FW: Outline Condition 10 (ref. P/69/26/DOC) - Land North of Sefter Road & 80 Rose Green Road, Pagham

- Point 4: *It is understood that the updated 2 No drawings relate to the boundary ditch/flood bund feature variations. The applicant however has not provide any summary to explain the situation for this application. This summary must clarify the variations from the approved design and clarify any issues raised by ADC following site inspections.*

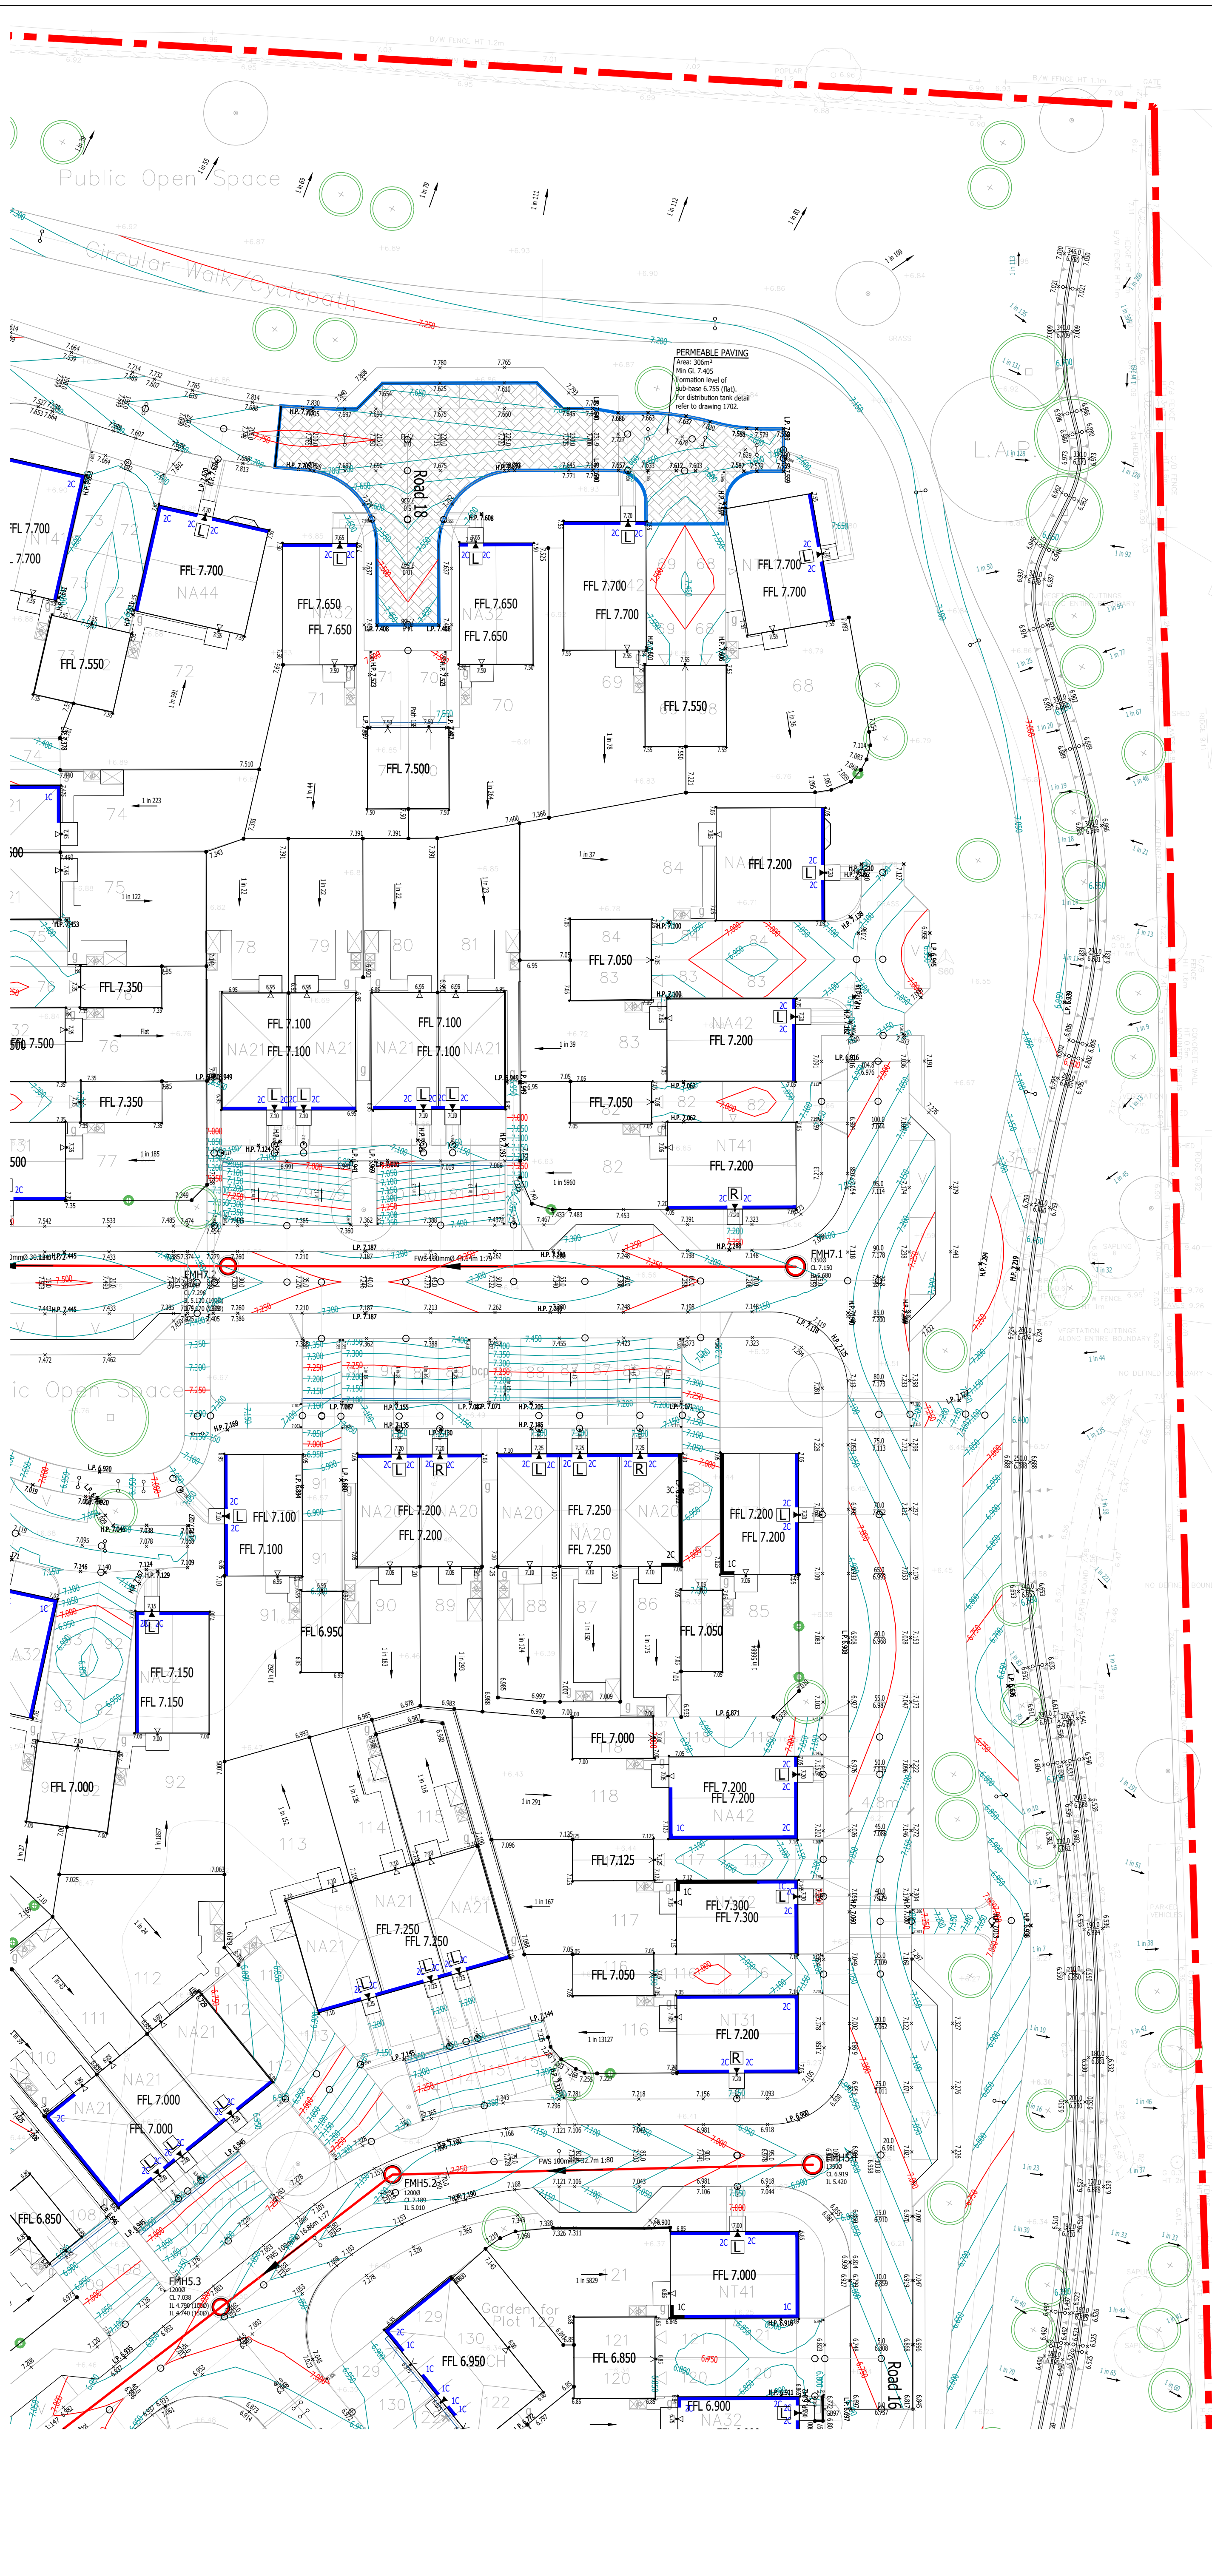
- Point 6: *Further to comment 4 above, it is evident that the flood bunds and swale are to provide some mitigation for exceedance flow. Further evidence is require to determine the impacts of these local catchments where this is partially footway (impermeable) and verge (greenfield run-off). This shall be quantified and re-modelled within the 1D calculations to conclude there is sufficient provision within the receiving SUDS basins/network*

As outlined in the covering letter submitted with this application, a site meeting was held on 6 March with Paul Cann following a complaint made to ADC by a neighbouring resident.

To address the neighbour's concerns regarding the potential risk of flooding to their garden, and although such a risk is considered unlikely, a ditch and bund arrangement has been incorporated along the eastern boundary as a precautionary measure. This feature is intended to manage any surface water runoff that may occur and to provide reassurance in response to the concerns raised.

The surface water run off is minimal yet as a precautionary measure to appease concerns of the neighbours abutting the site we have worked with our engineer to amend the drainage design to manage the concern. Calcs can be provided if necessary following conformation with Paul Cann that this is satisfactory solution following the site visit.
